**From:** NICK HOCKEY <[REDACTED]>  
**Sent:** 20 June 2018 11:56  
**To:** Amber Willard  
**Subject:** Planning Application R/107/18/PDH

Re. 23, Preston Avenue, Rustington, BN16 2DF

SECTION AA EXISTING SIDE ADDITION

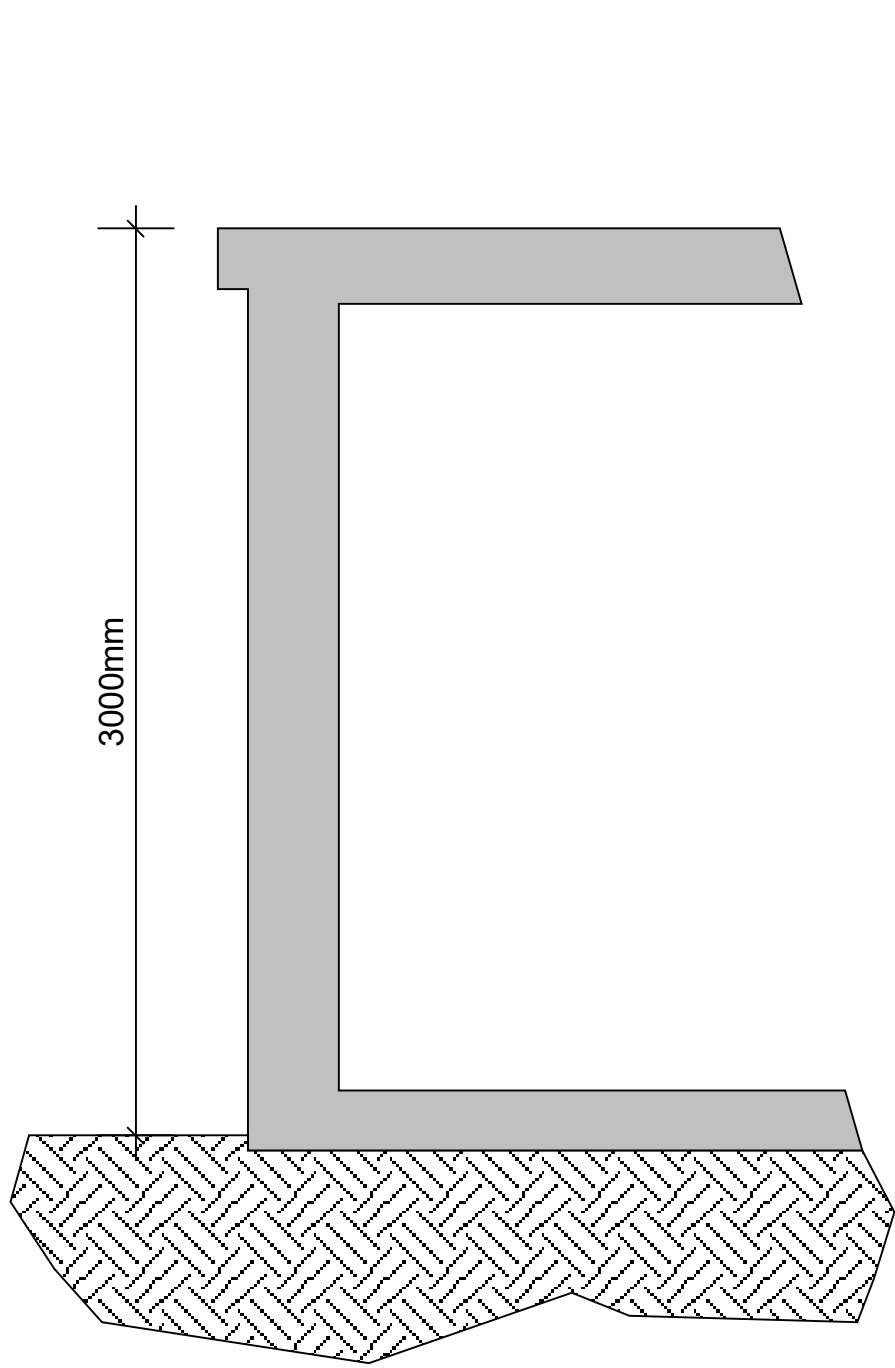
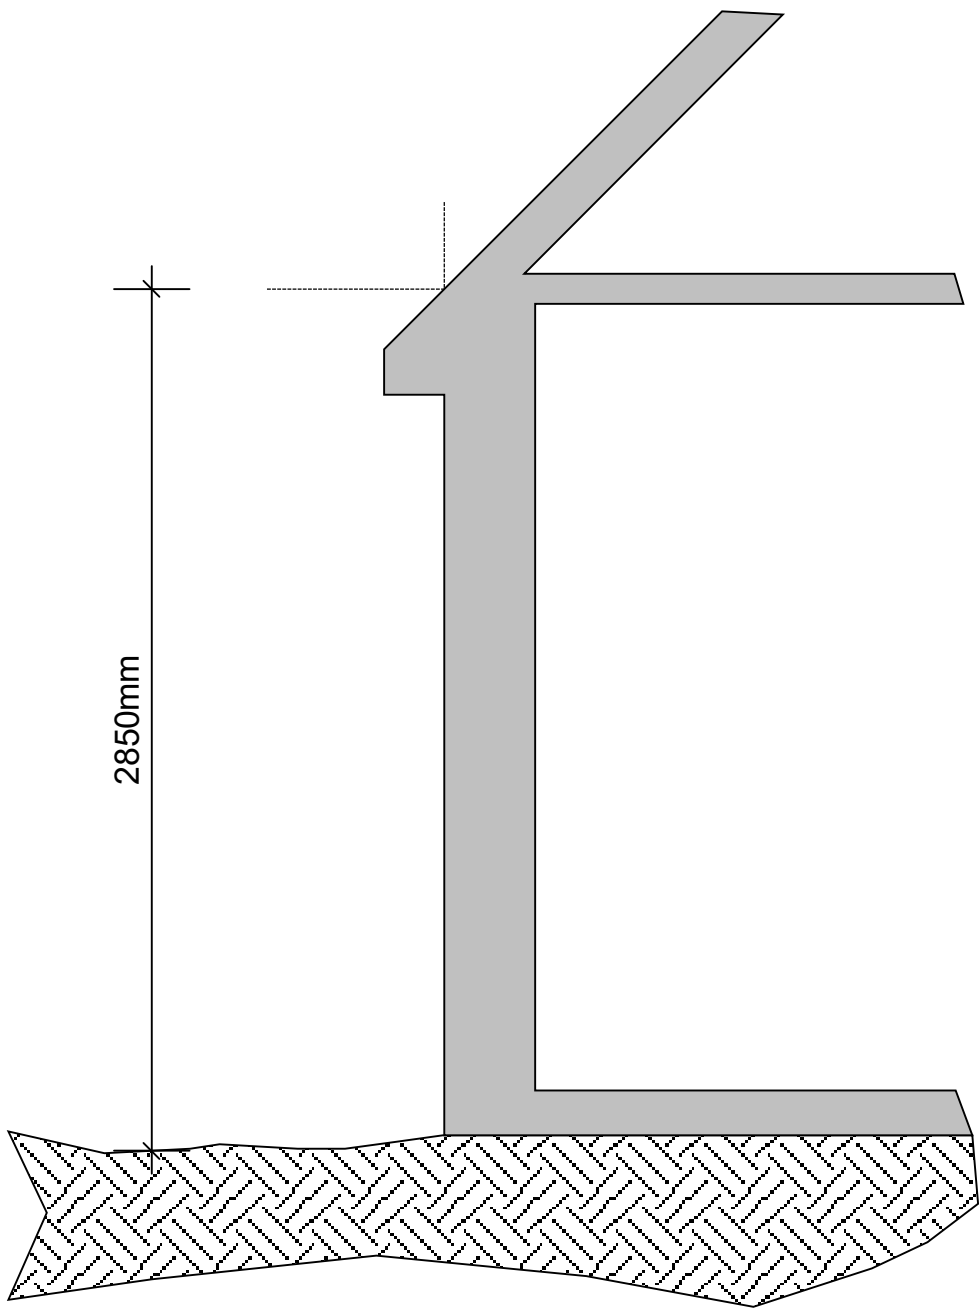
1. The title deeds plan shows the original garage to West side set back level with front of house, and built with a gap to boundary fence.  
Following the planning applications approved 1967 & 1968
  - a) the garage moved forward from the adjacent front of house, but the height and gap to boundary maintained.
  - b) a workshop extension to original garage (behind new garage) built at an increased height and width extended to the boundary.
2. Our understanding is that the definition of eaves height refers to the lowest point of the tiled roof and this is c.2.4m,  
i.e. lower than the proposed 2.85m shown in 'Section BB' of plan submitted 20/6/18. Hence our contention that the proposed 2.85m extension roof height does not comply with Sch2, P1, A.1(d), nor A.1(k)(iv) since it would require alteration to the tiled roof between 2.4 & 2.85m.
